Our Ref: FP/235/19/HH

**Town & Country Planning Act 1990 (as amended)
Town & Country Planning (Development Management Procedure) (England) Order 2015
Application for Planning Permission for Works or Extension to a Dwelling**

Development Proposed 2 Storey extension to the South elevation with pitched barn hip roof, Small dormer to North Elevation

Location 26 Roundle Avenue Felpham

5 Proposed Ground Floor
1 : 50

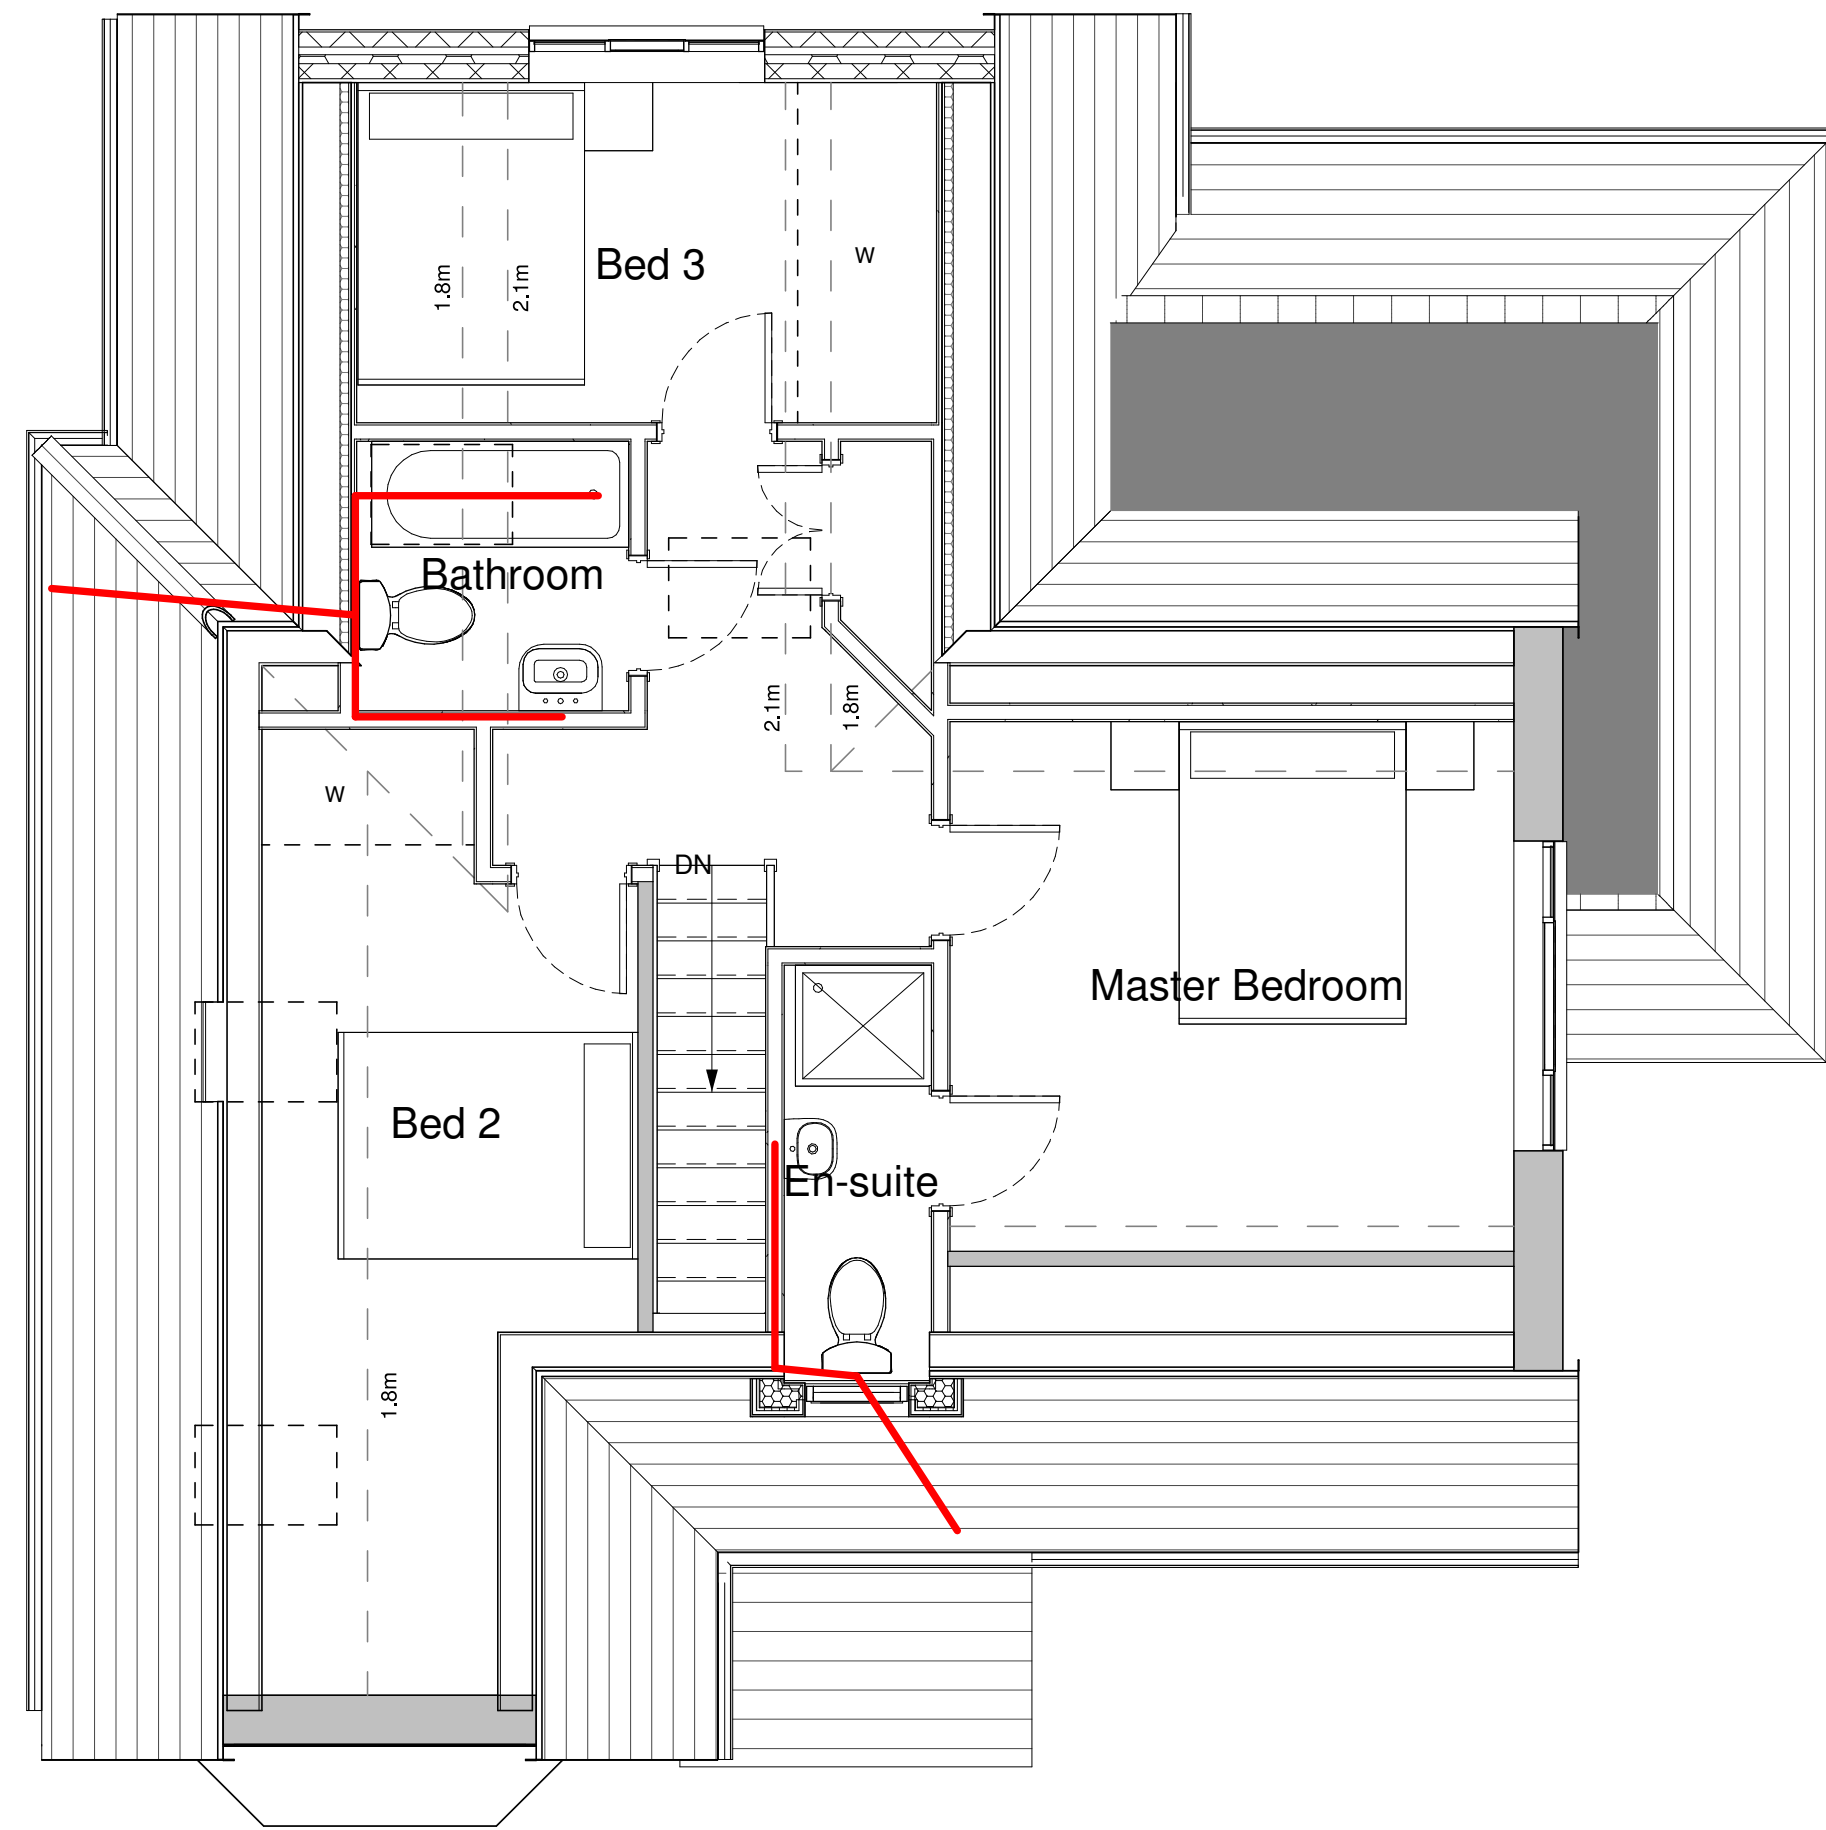
Room Labels: You are required to have room labels on all your floor plans.

1 Block Plan

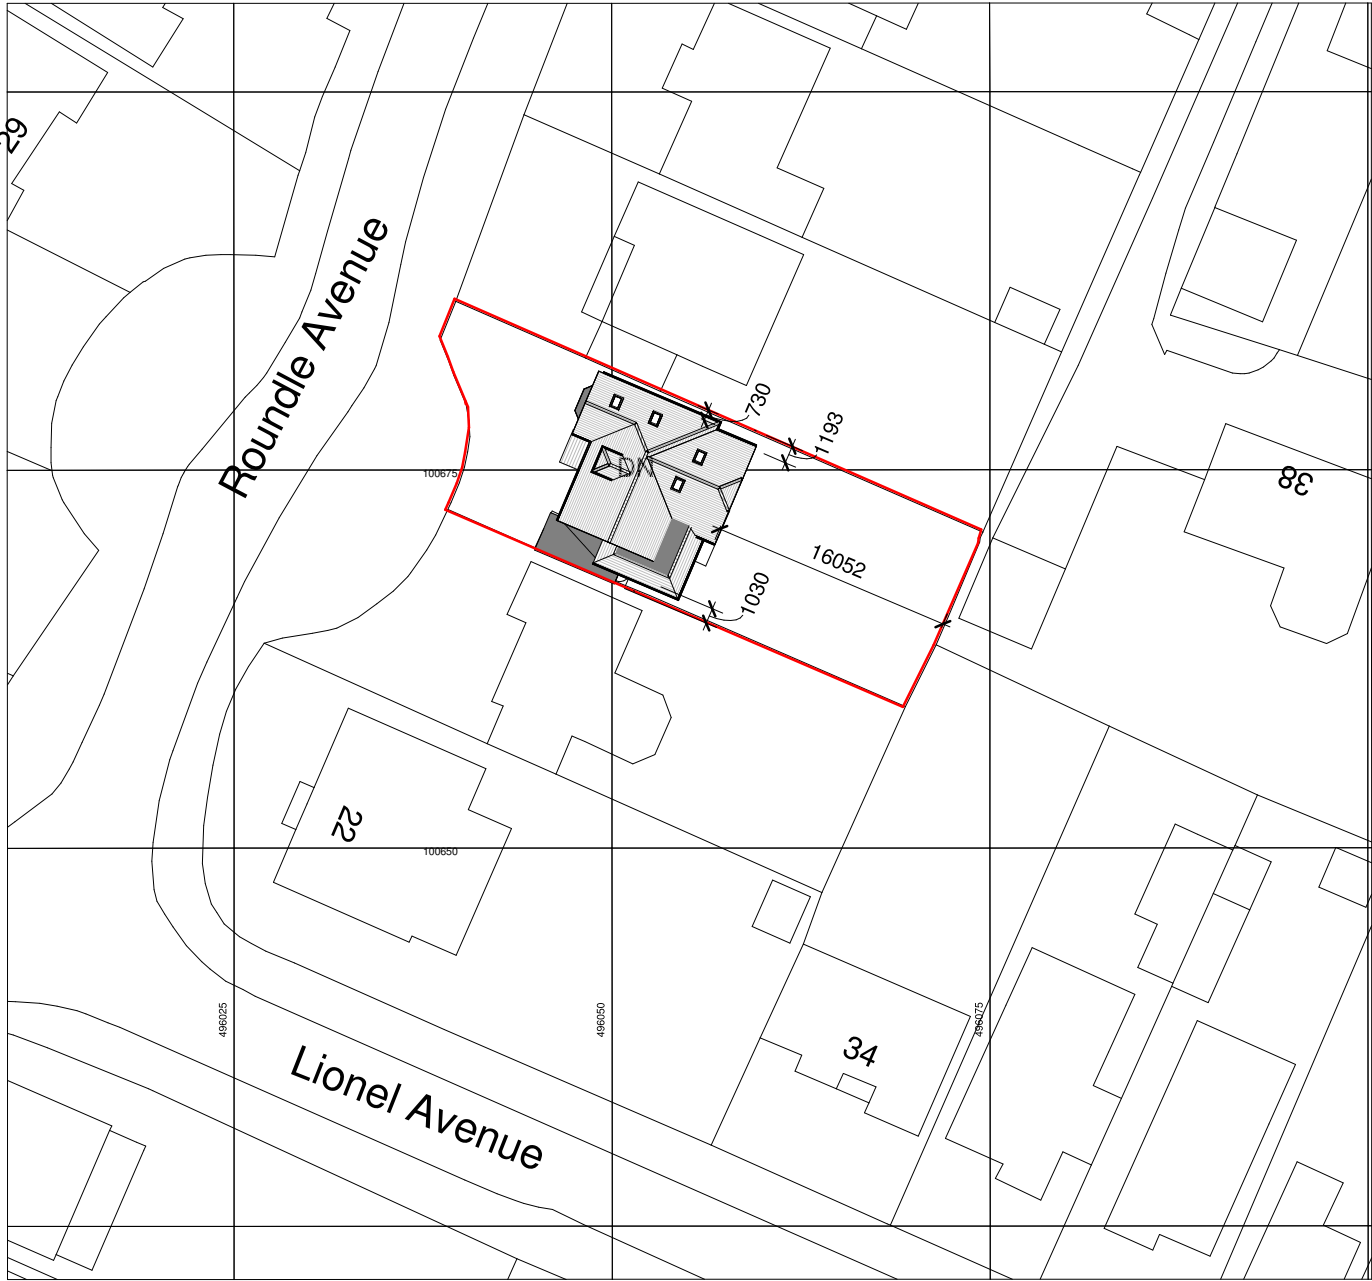
Dimensions: You are required to include dimensions on the block plan from the proposed extensions to the site boundaries.
